Our Ref: EN010098

## **Planning Act 2008 (as amended) – Section 51**

### **Application by Ørsted Hornsea Project Four Limited for an Order Granting Development Consent for the Hornsea Project Four Offshore Wind Farm**

#### **Advice following issue of decision to accept the application for examination**

Coordinate system: British National Grid
Vertical reference: ODN
Scale @ A1: 1:2,500
0 25 50 100 Meters
0 25 50 100 Yards
GRID NORTH

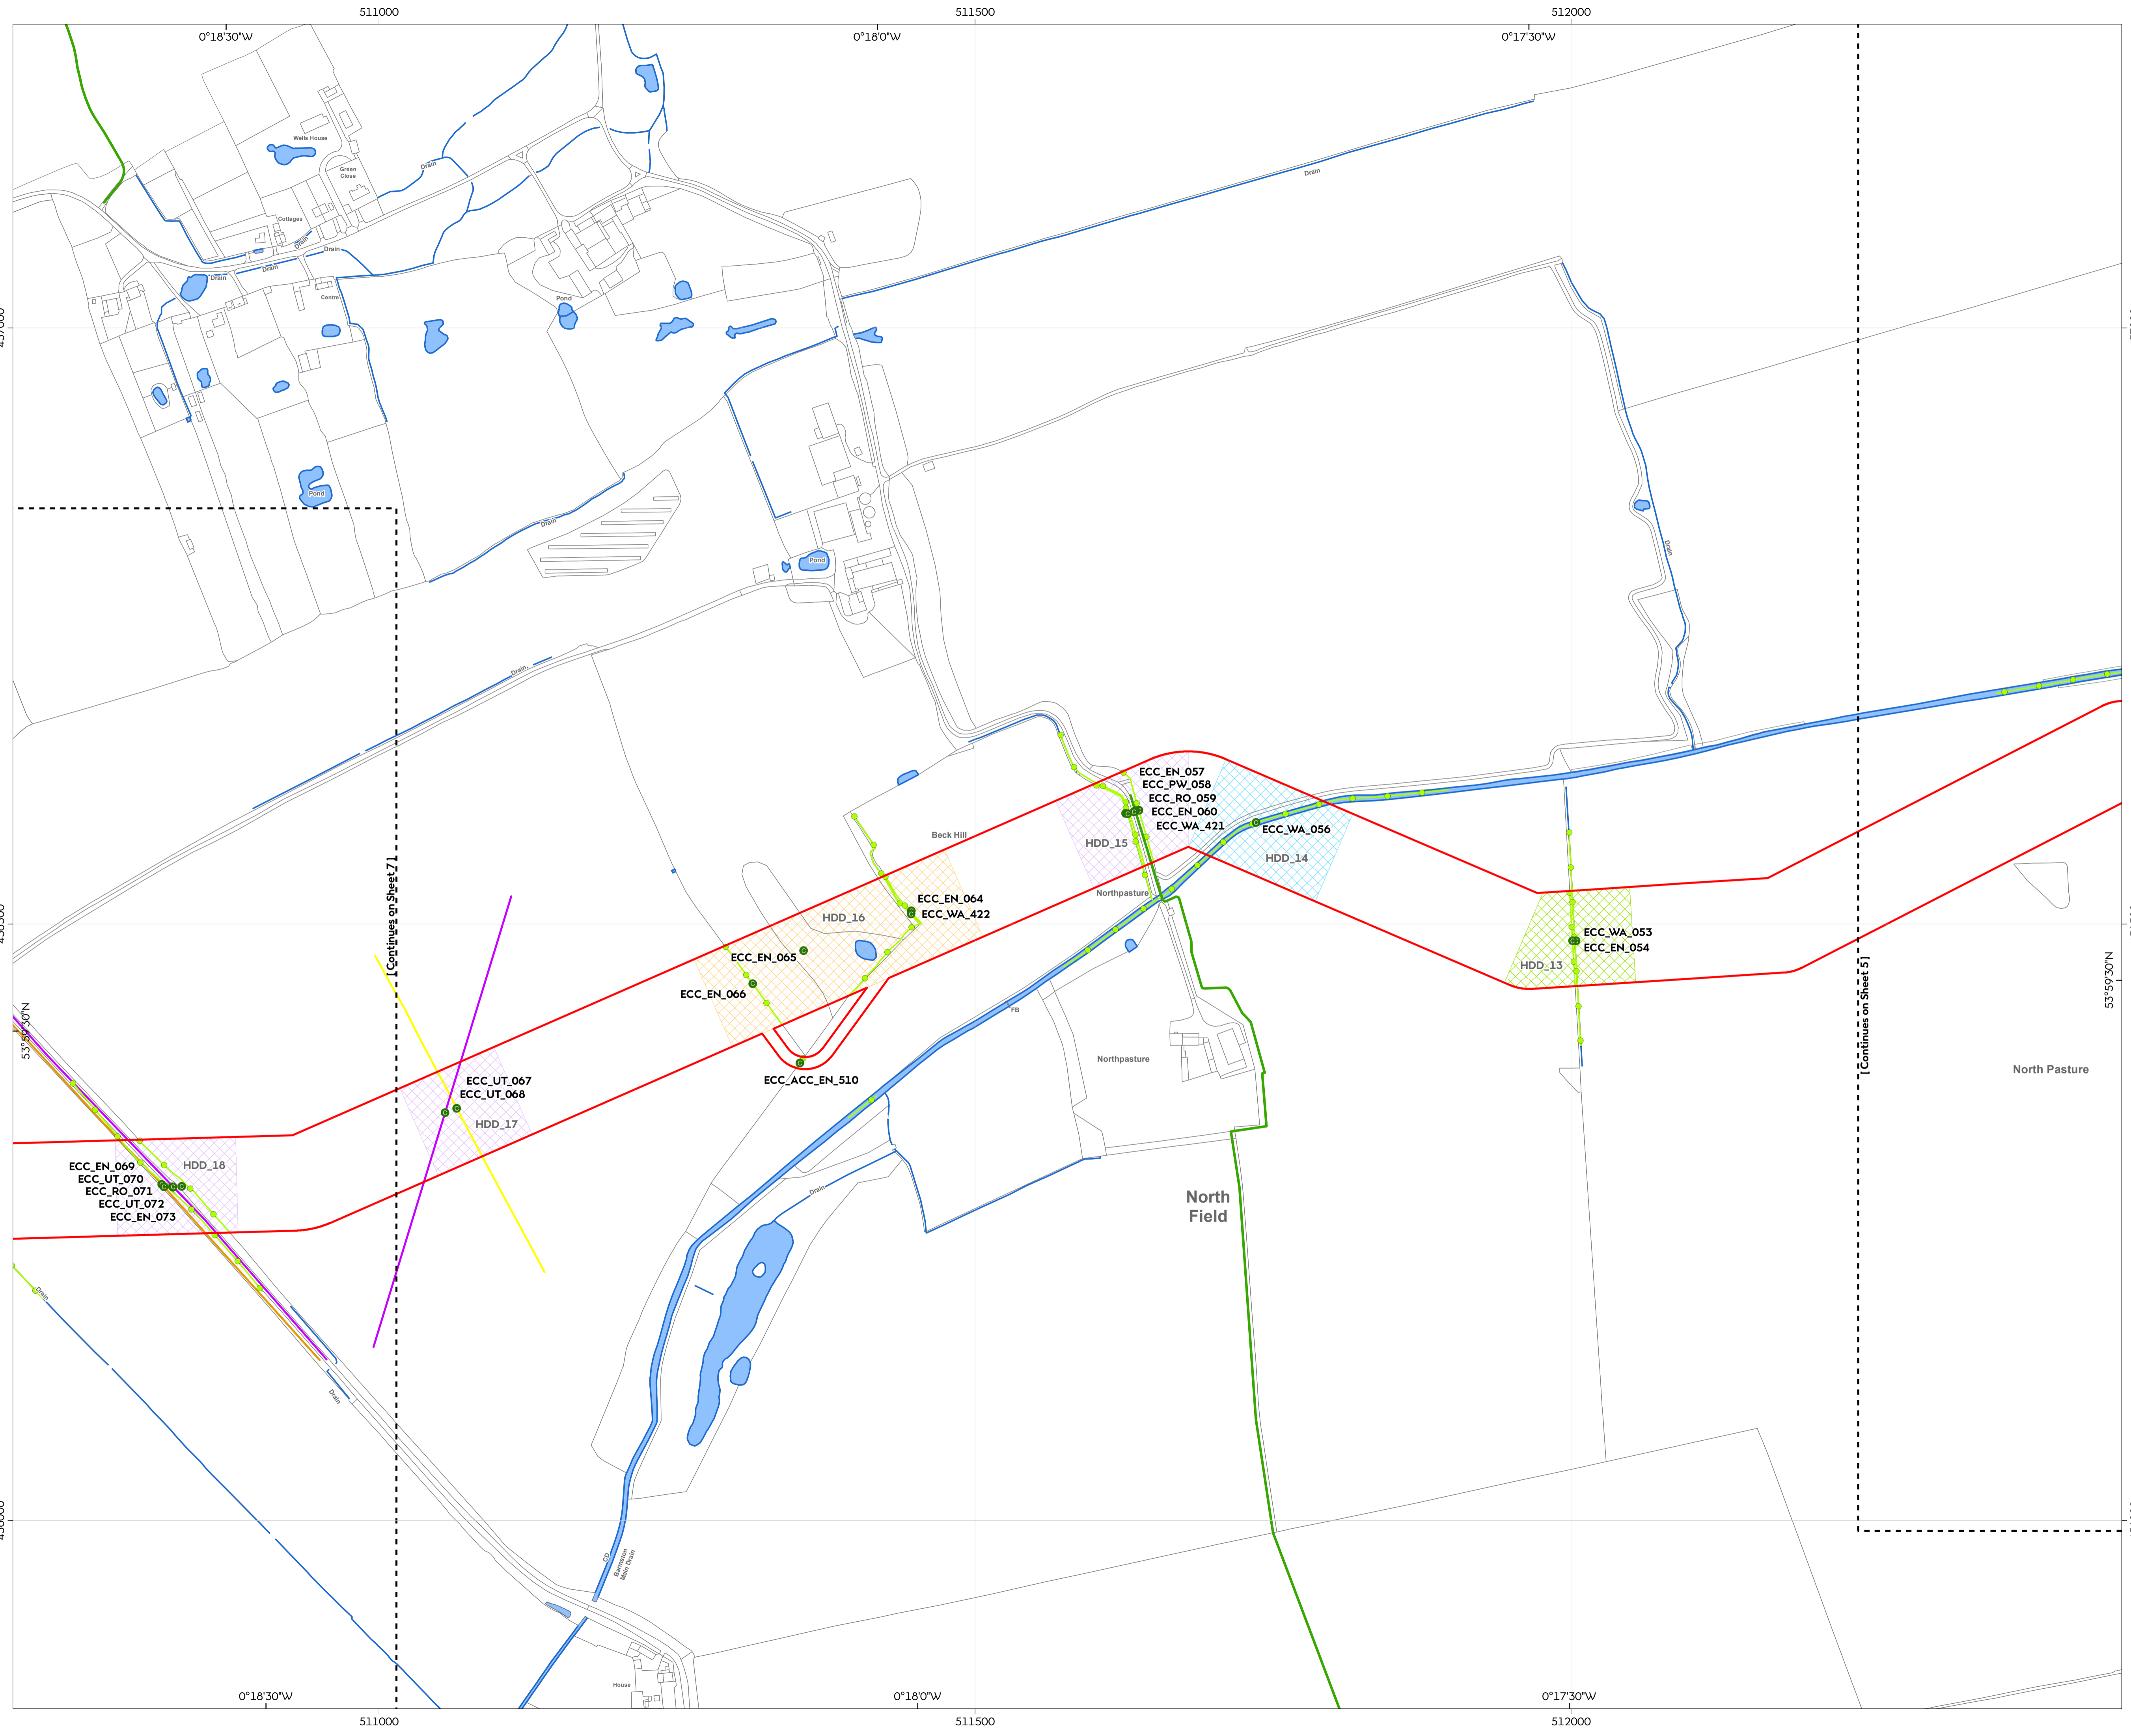
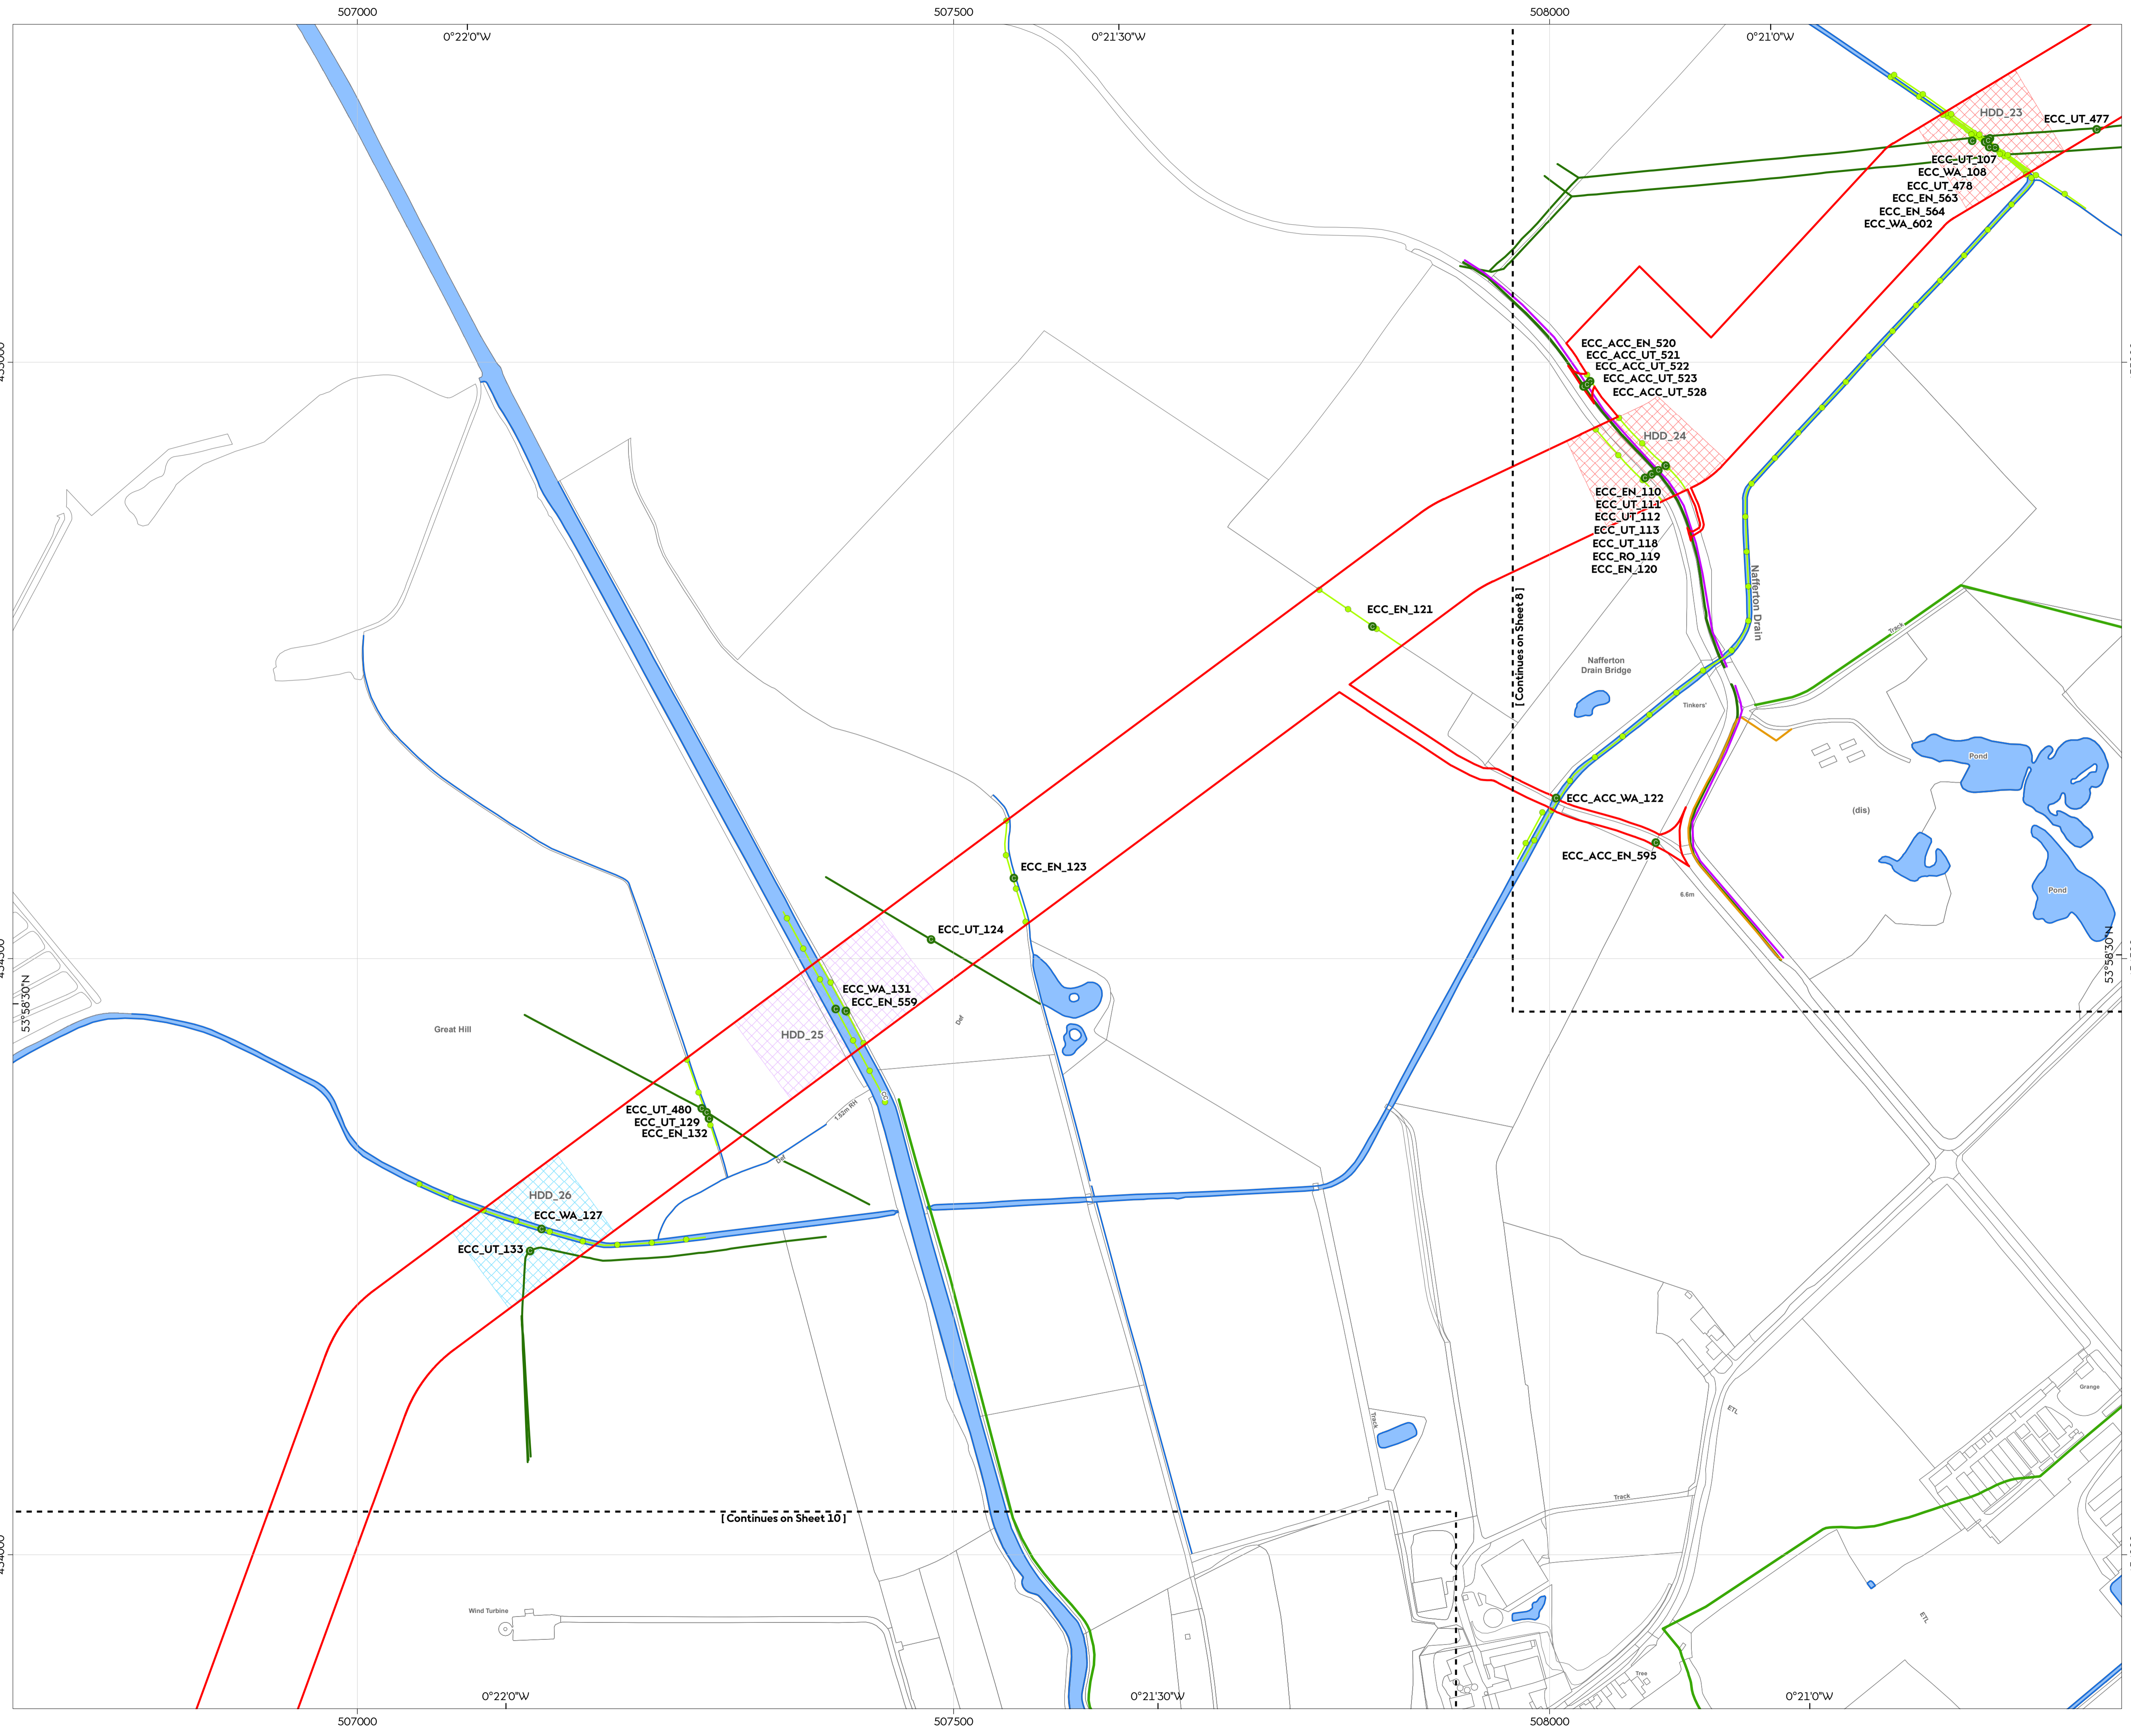
The location of all HDDs is presented in the Onshore Crossing Schedule (Doc A4.4.2). However, this document is not referenced within the draft DCO (Doc C1.1). If HDD is proposed to mitigate any environmental effects the Applicant is advised to ensure that its delivery is secured.

Figure: 1
Viewpoint 1: PRow South of Burn Park Farm

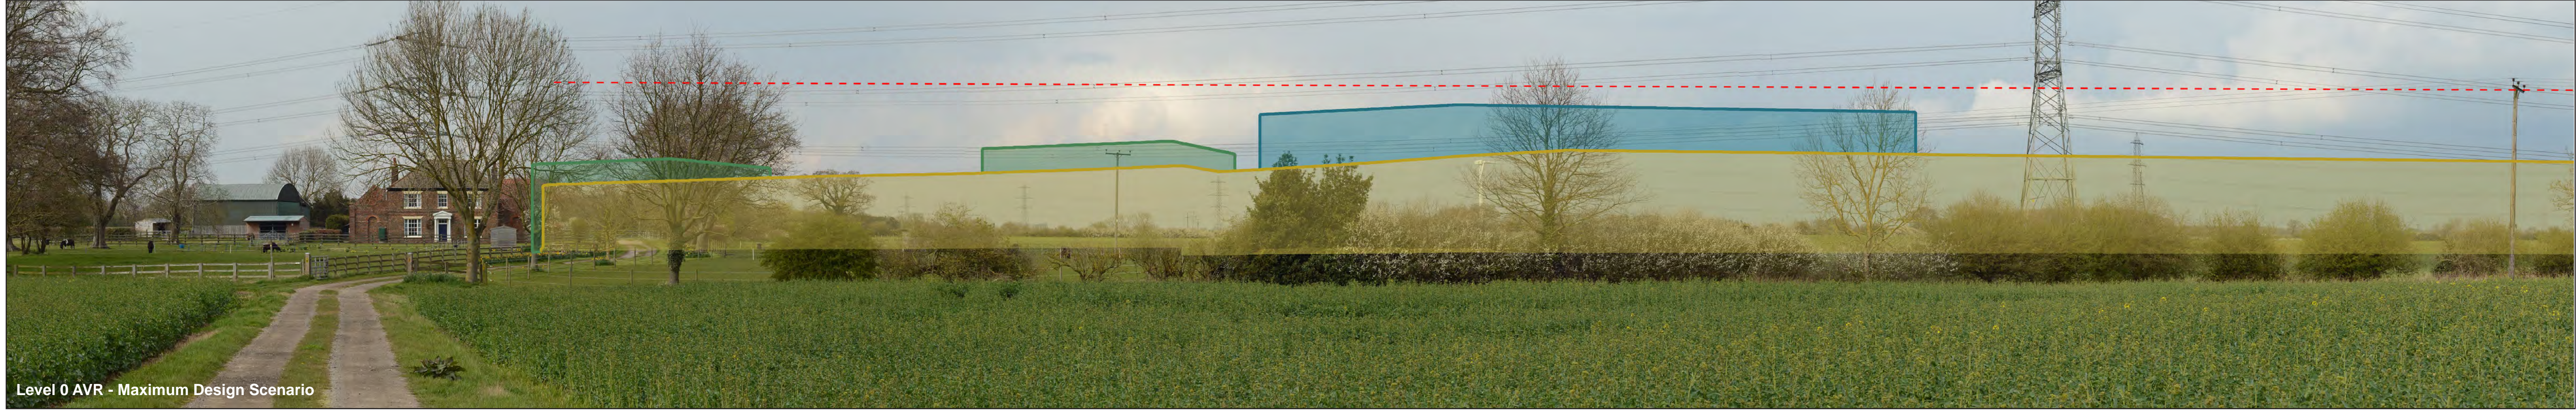
It is noted that the ground levels for the onshore substation and EBI are proposed to be set post-consent through a requirement. No maximum or minimum existing or finished ground or floor level parameters appear to be provided, only 'likely levels'. Greater clarity should be provided on how the Examining Authority (ExA) and Secretary of State (SoS) could rely on any Development Consent Order (DCO) to control this, and the basis that was adopted for each of the relevant assessments, especially the Flood Risk Assessment (FRA) (Doc A6.2.2) and the Landscape and Visual Assessment (Doc A3.4) and accompanying visualisations (Doc A6.4.1).
